**DEVIATION REVIEW
 AND DECISION FORM**

Deviation No. 3
REV. 2-8-2019

Subdivision or Project Name: Rollin' Ridge Estates

Section of ECM from Which Deviation is Sought: 2.3.7.E Intersections - Turn Lane Design

ENTRY DETAIL

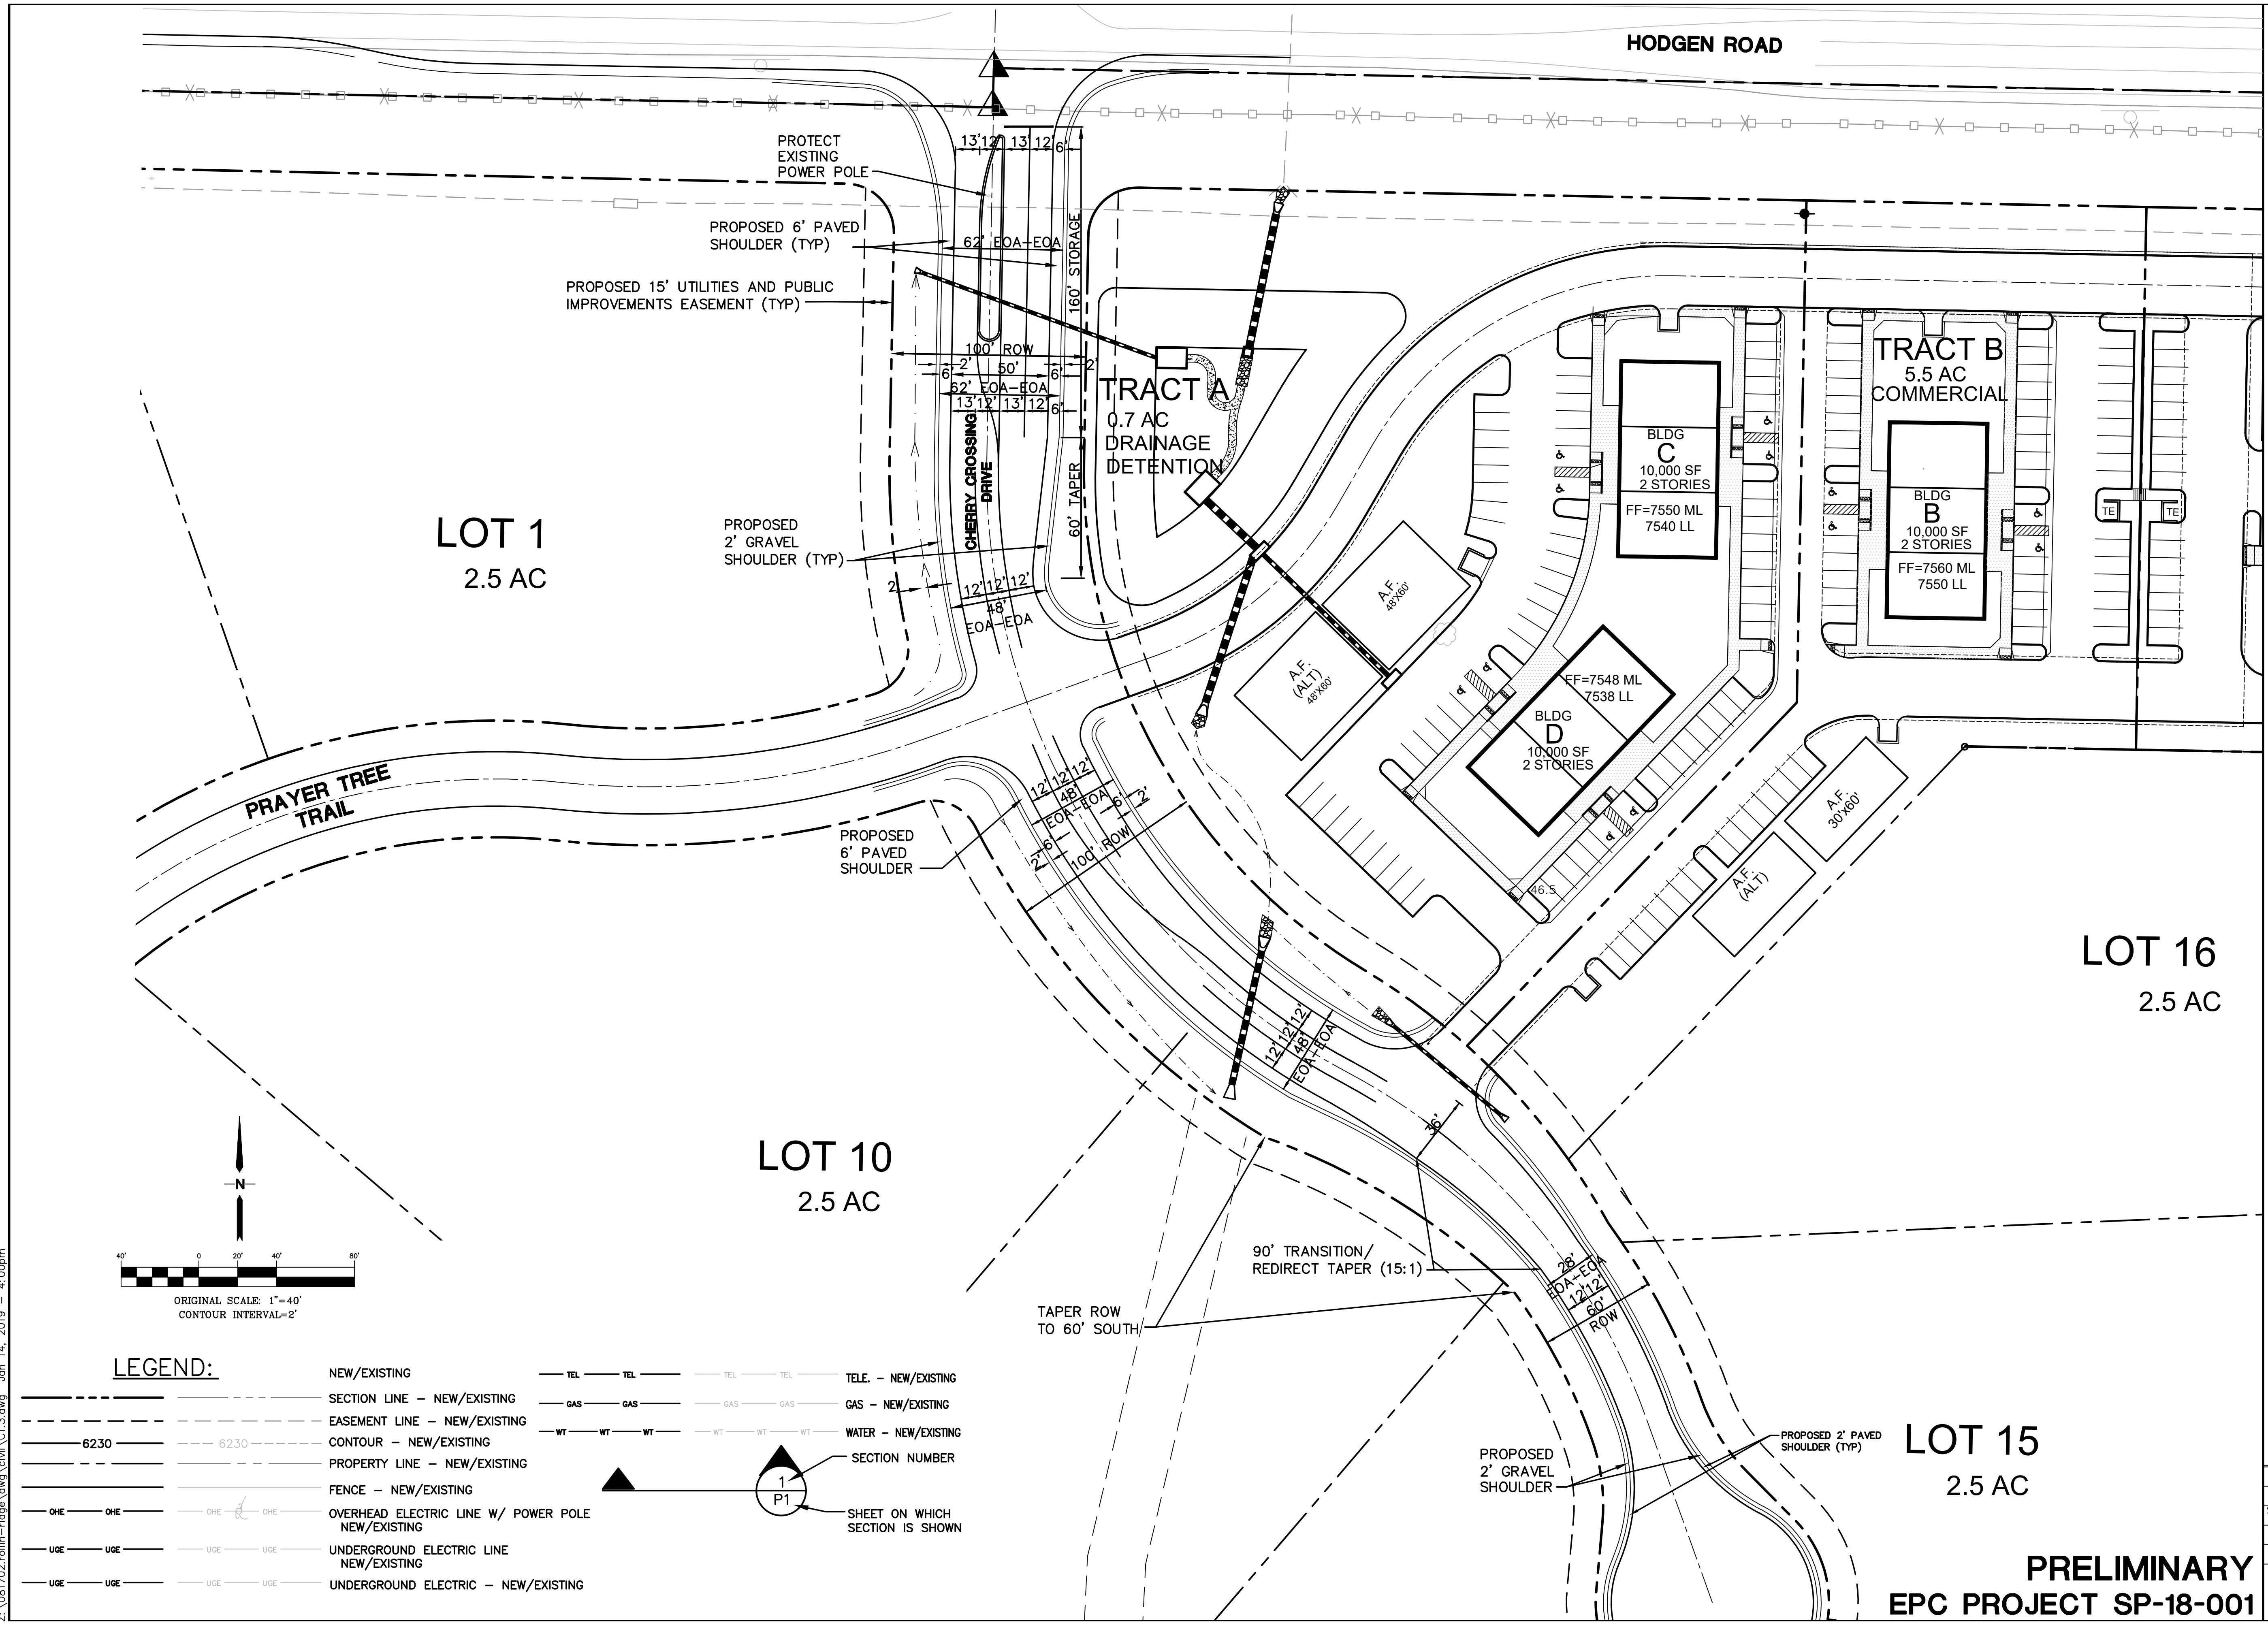
Proposed Nature and Extent of Deviation: Allow abbreviated northbound right-turn deceleration lane (160-foot-long lane) and lane taper (60-foot-long taper) at the intersection of Cherry Crossing Drive and Hodgen Road. Please refer to the proposed laneage plan shown in the attached exhibit.

The proposed design is based on a limited street design lane condition. **what about the required decel length for a 30 MPH road? Have you analyzed if a acceleration lane on Hodgen would be beneficial to allow for almost free movement off of Cherry Crossing onto Hodgen? Please describe the proposed movement at the intersection (where will the stop condition be located) of Cherry Crossing and Prayer Tree.**

The proposed 60-foot taper will be appropriate for this situation. The taper has been kept relatively short to maximize stacking distance and tie into the radius on the northeast corner of the commercial access. A "continuous right turn lane" was considered, which would essentially extend the turn lane back to the north commercial access intersection. This would presumably be striped for entry only by westbound right turns exiting the site (similar to a right-turn acceleration lane). However, it was our judgement that it might create potential driver confusion and unnecessary conflicts with two northbound lanes extending north from the intersection. If the staff would prefer a continuous lane, this could easily be changed on the plans.

Staff would prefer a continuous lane. Please update the plans and traffic study.
